15 December 2016

Department of Planning & Environment
GPO Box 39
Sydney NSW 2001

Response to Submissions – Section 75W Modification Request for
Miranda Dental Hospital (MP_11_0009 MOD 3) at 86 Kiora Road,
Miranda

Figure 5: Loading Bay Configuration

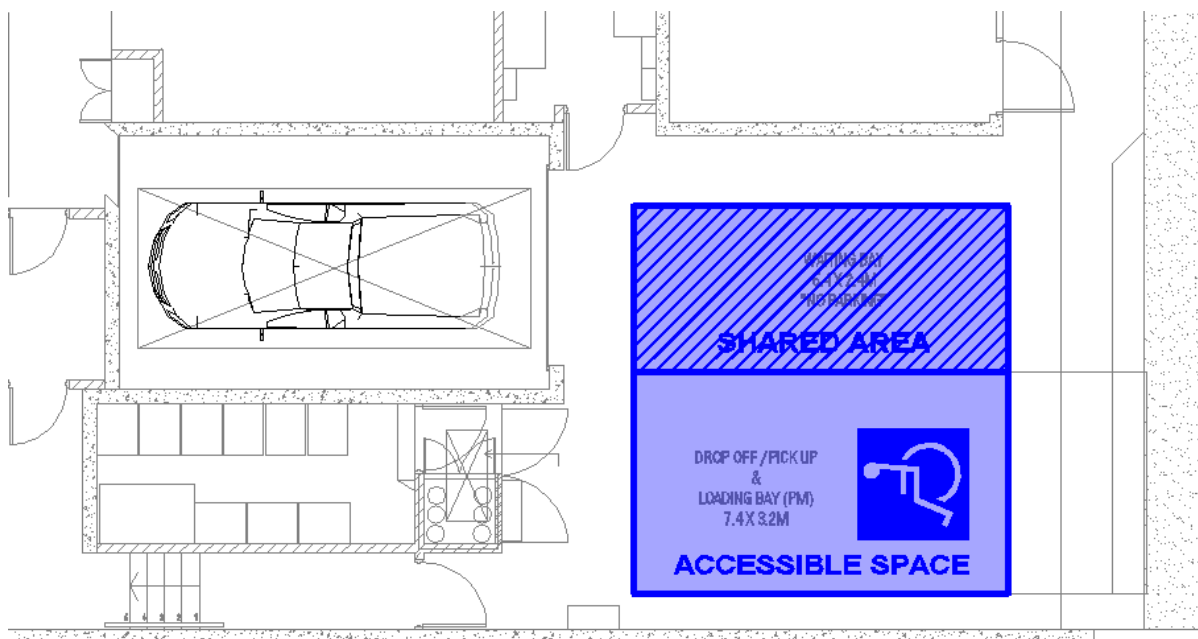
Council has raised concerns about sharing of the disabled parking space with the loading bay.

Assessment of the provision of access for people with a disability at the drop-off area near the valet car parking service has been undertaken (refer [Appendix 2](#)). Note: the two car spaces in the drop off area are only for drop offs and not parking.

The assessment concludes that the drop-off area is designed to minimise the risk of a Disability Discrimination Act (DDA) complaint and in accordance with the recommendation of report, disability access as proposed will be monitored by the occupants on an ongoing basis to ensure all obligations under the DDA are met.

It should be noted that disabled persons in wheelchair being dropped off by car will always be assisted by either the driver or the on-site valet. There is a valet in the driveway to assist with disabled drop off, car lift operation and managing traffic. When a disabled person is being dropped off, the valet will put a cone or signage to stop traffic from entering the driveway. A van for wheelchair can also drop off in the driveway stopping diagonally as demonstrated in the DDA report as an alternate solution.

Appendix 4 – Extent Overland Flow in Norfolk Lane Plan (A3)

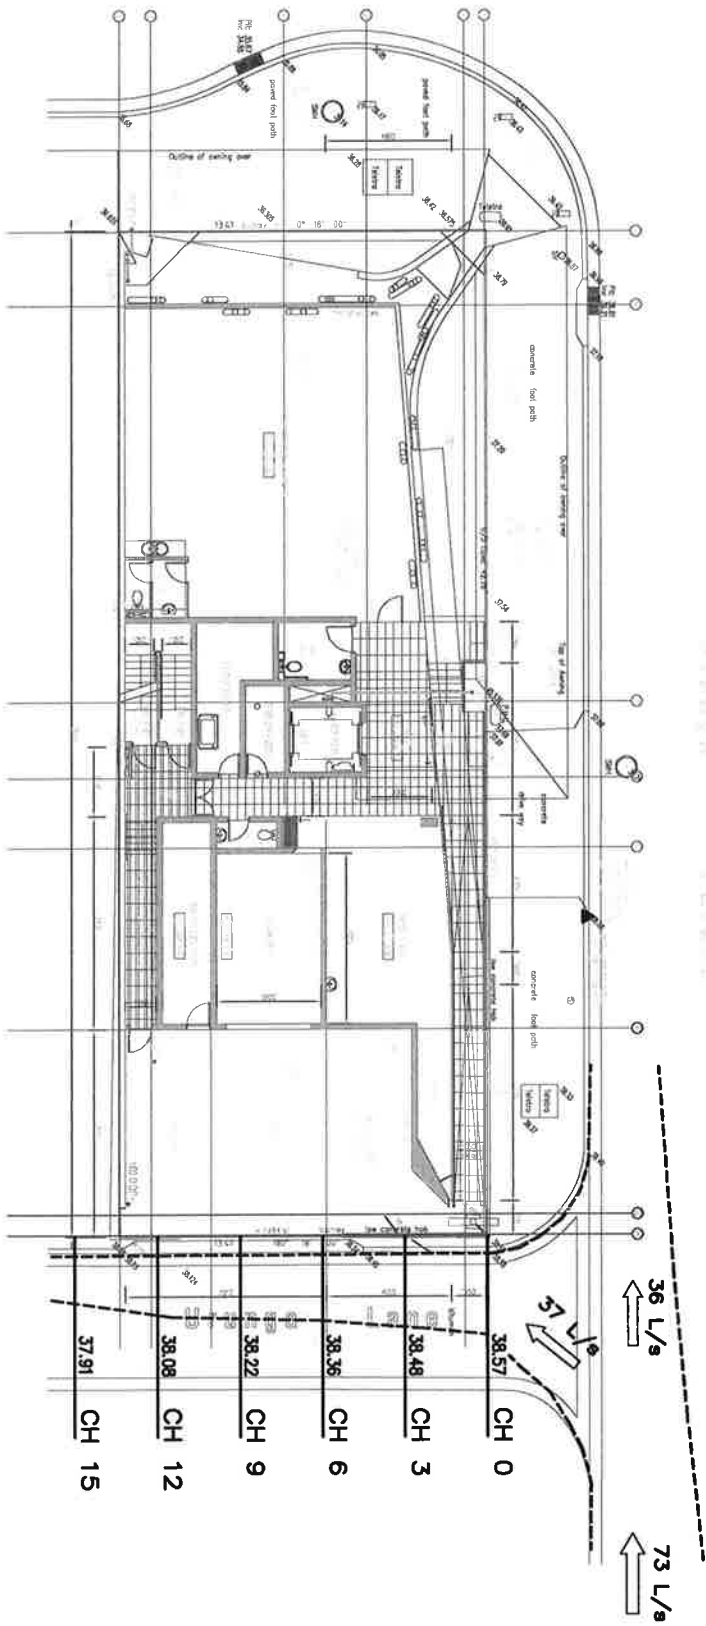
- Consideration be given to flows from Jackson Avenue;
- Analysis to be done assuming 50% pit blockage;
- Analysis to be done for all storms from 1 year ARI to 100 year ARI; and

- Analysis of flows at the end of Urunga Lane

The issues of concern raised by Council have been clarified and adequately addressed by our consulting engineers (refer [Appendix 4](#)).

LEVEL 5 FLOOR PLAN & ROOF PLAN

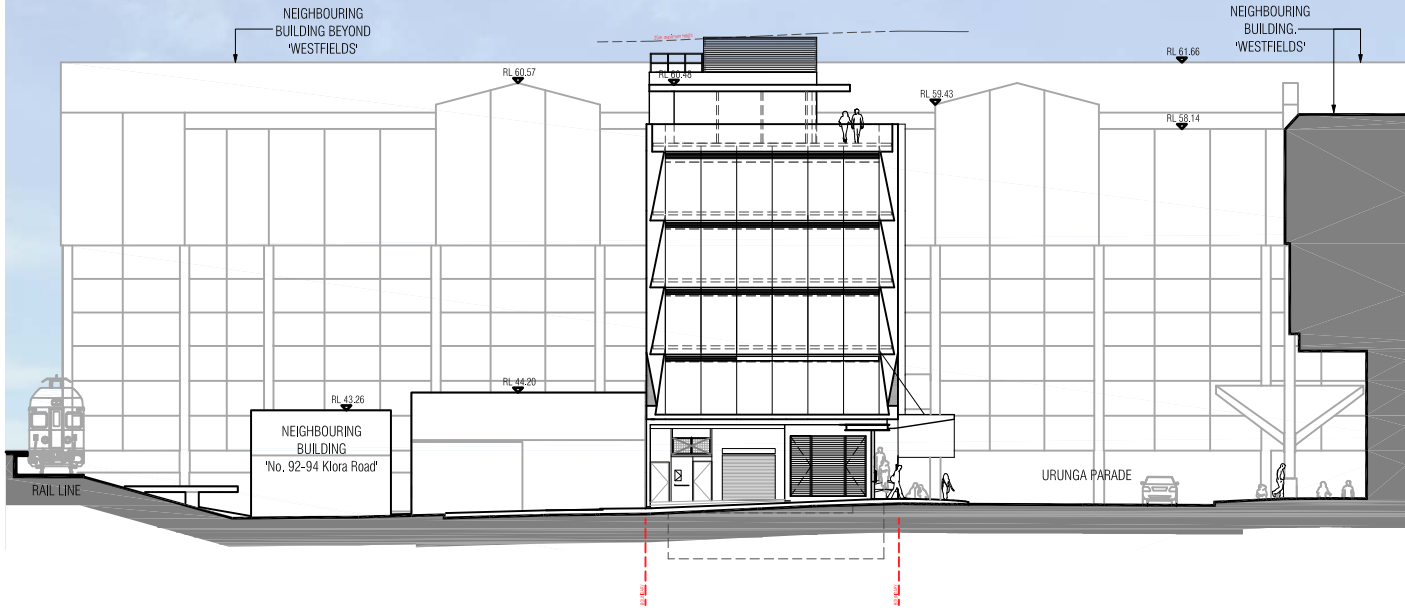
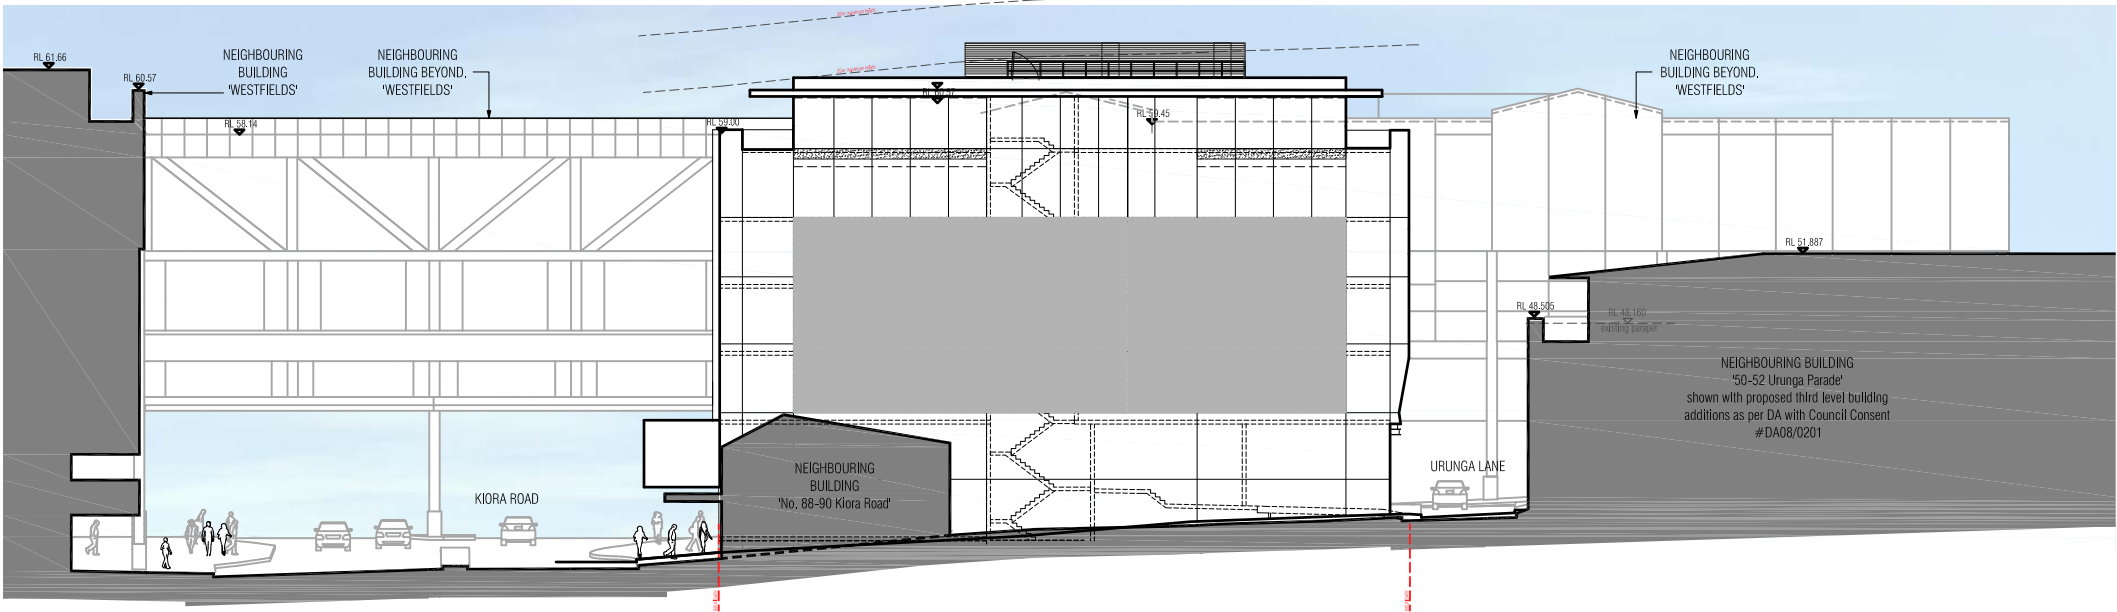
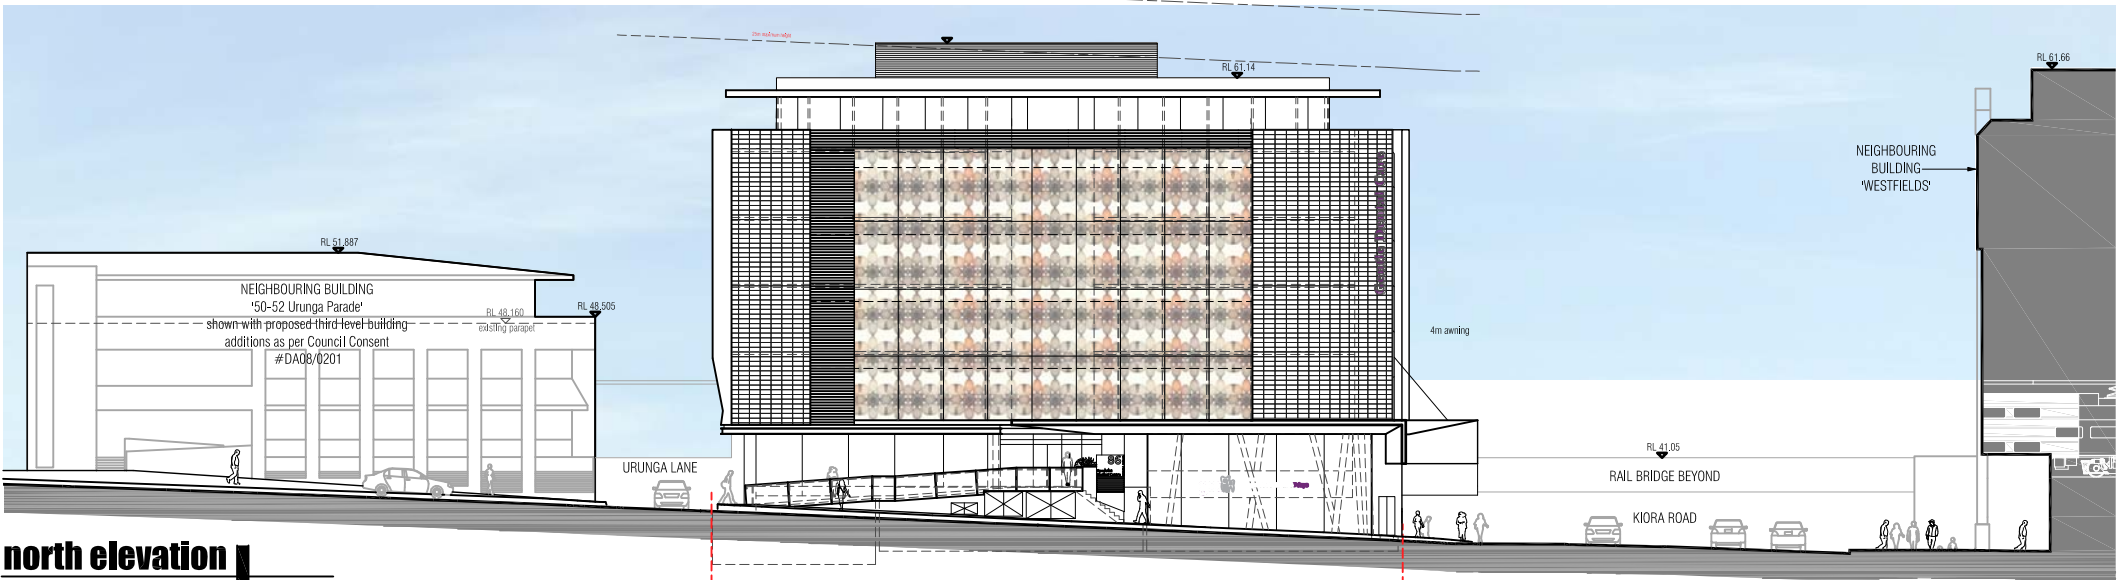
Council has raised concerns that no justification has been provided for the increase in building height that sees the lift over run and plant room exceeding Council's 25m building height limit.

Detailed plans showing where Council's 25m-height limit intersects the rooftop louvre screened plant room accompany this submission (refer [Appendix 3](#)).

- The parapet height of the building is increased by 1.89m as a direct result of structural engineers detailing for beam sizes in combination with the requirements for air conditioning ducts in ceiling space.

- The maximum number of storeys applying to the proposed development at the time of the Concept approval was 28m.
- Only the roof top plant room louvre screening exceeds Council's current 25-metre building height limit by a maximum 0.47m at the northwest corner of the plant room (refer detail drawings in Appendix 3).
